Rezoning Transportation Analysis
Petition Number: Insert Zoning Petition #2021-213
General Location Identifier: 22706130

Revision Log:	Date	Revision Log:
	01/21/2022	First Review (WB)
	02/21/2022	Second Review (WB)
	04/19/2022	Third Review (WB)
	05/25/2022	Fourth Review (WB)
	06/13/2022	Fifth Review (WB)

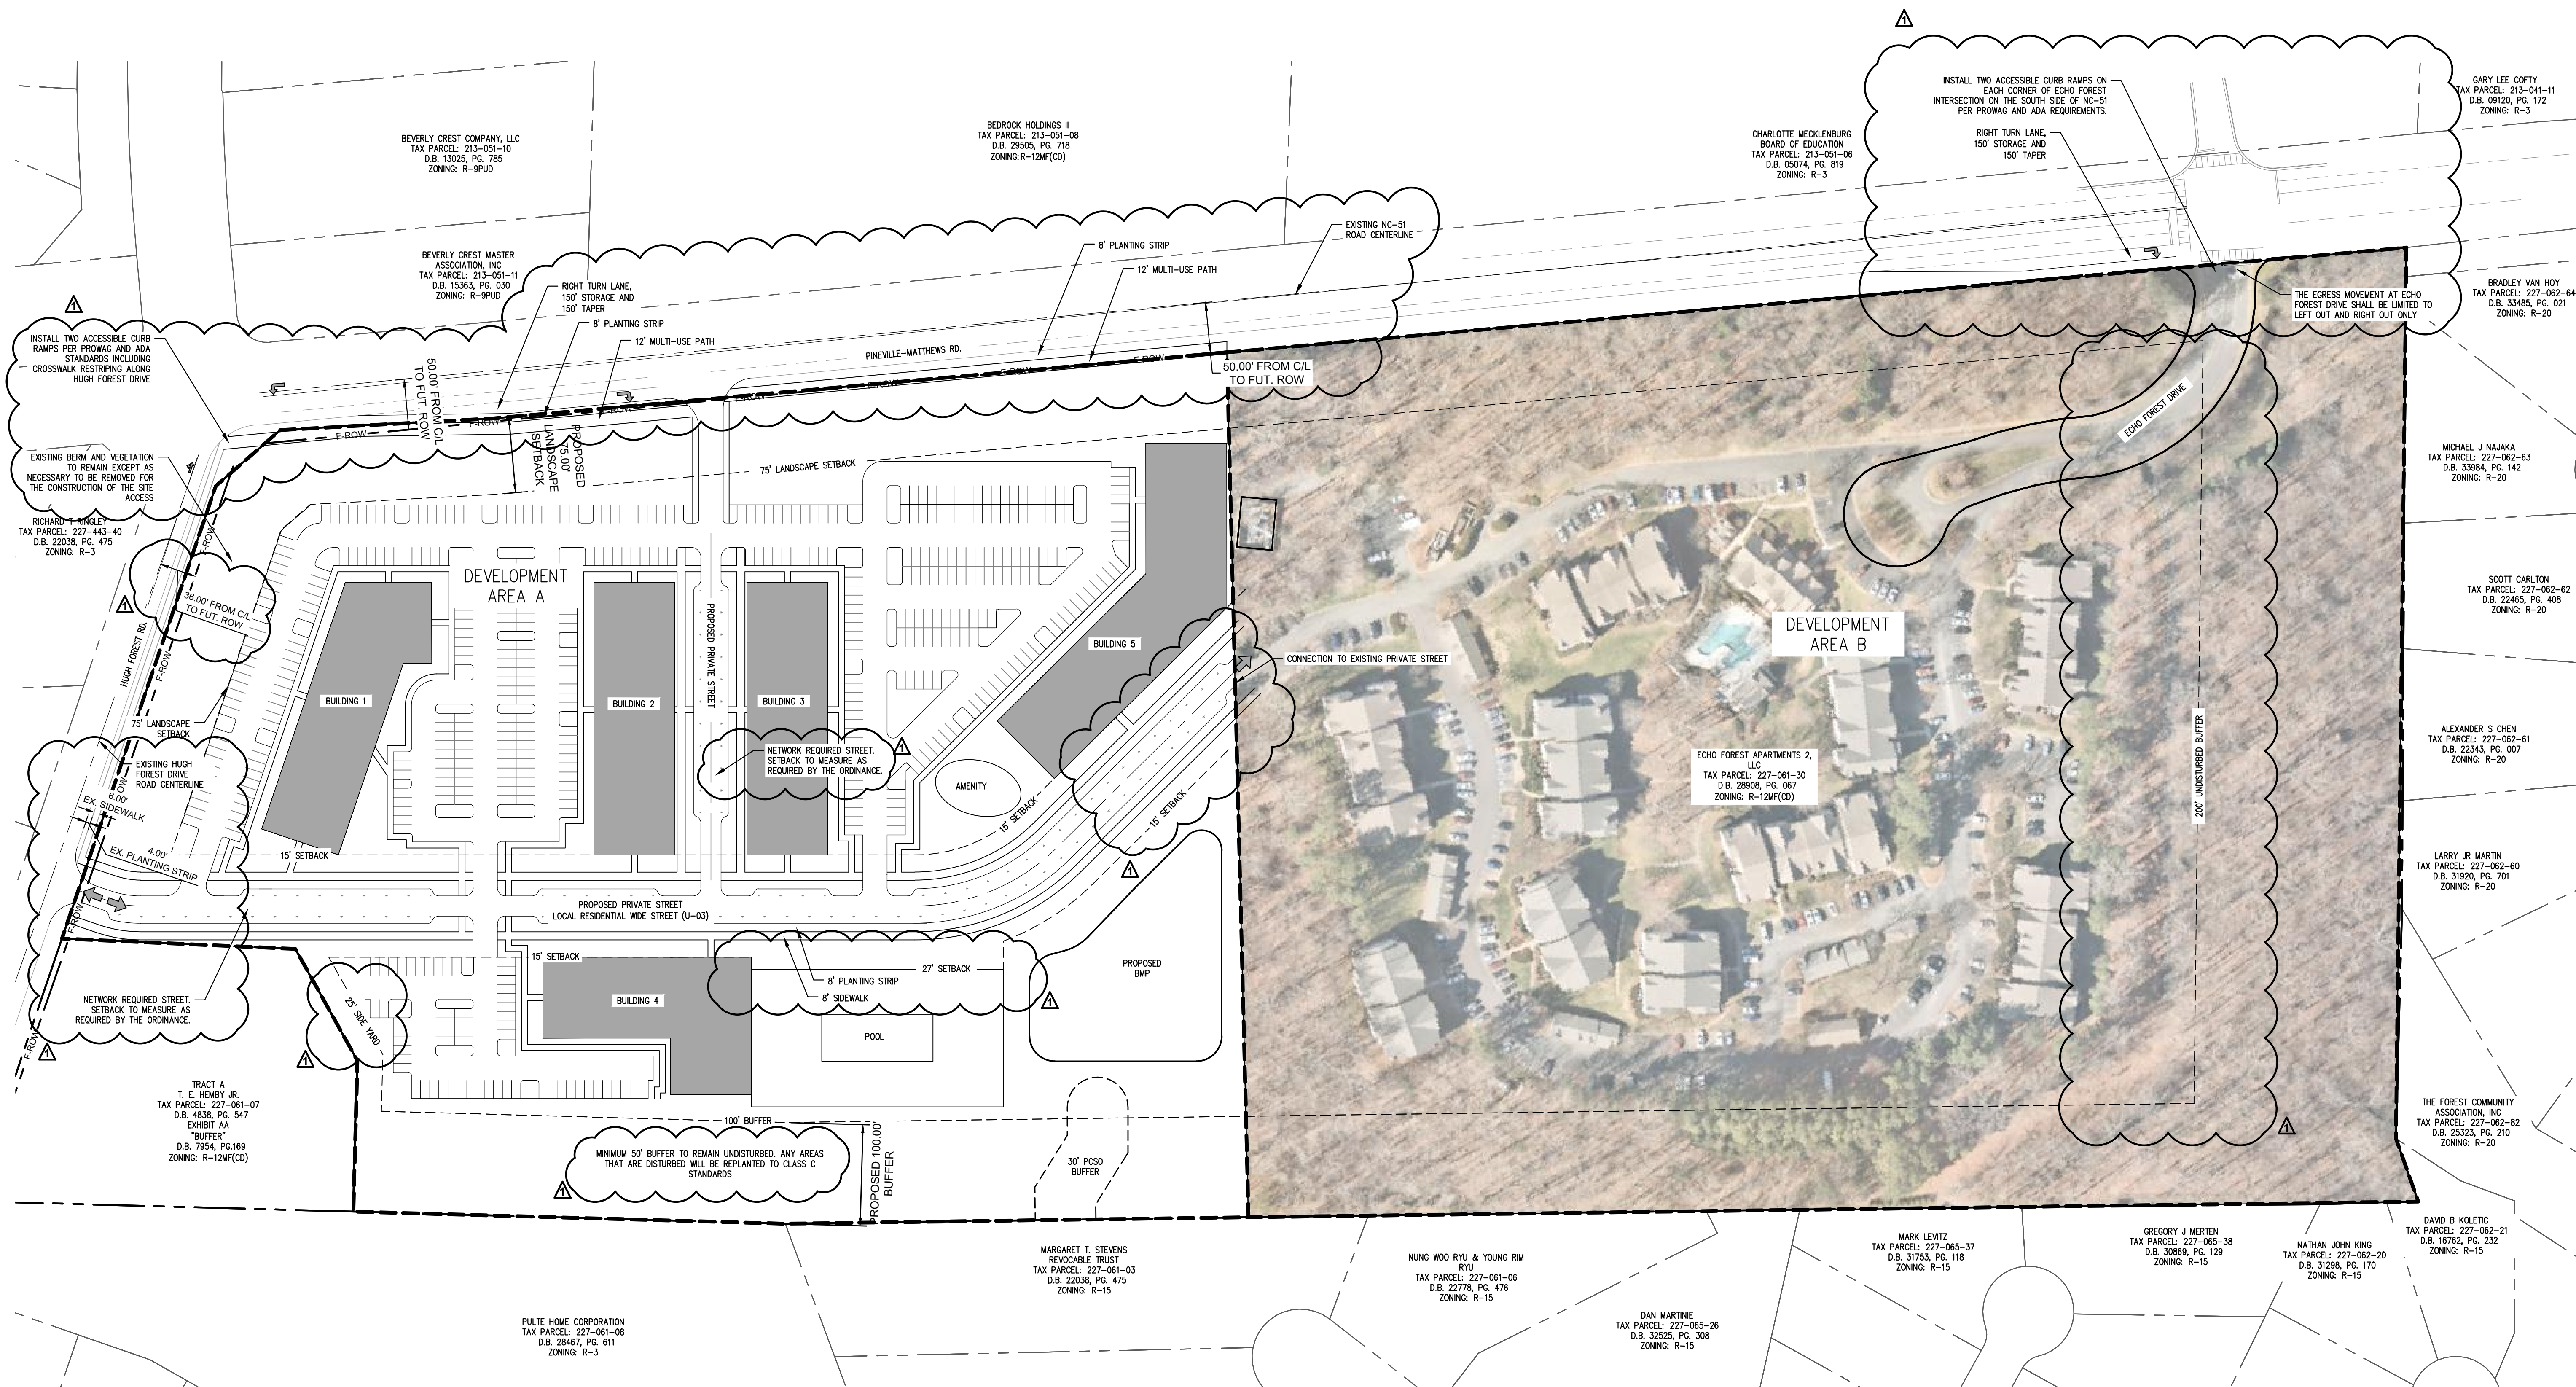
5. **Comment Clarification (Site plan reviewed on 2/21/22):** Site plan and conditional notes revisions are needed to commit to construct bicycle facilities by installing a 12-foot multi-use path along the site's entire Pineville-Matthews Road frontage in accordance with the Charlotte BIKES Policy. The site's frontage includes both Area's A and B.

Revise site plan and conditional notes to commit to constructing all TTM recommended improvements including, but not limited to, restriping the south leg of the Hugh Forest Road intersection to maximize turn lane storage on Hugh Forest Road.
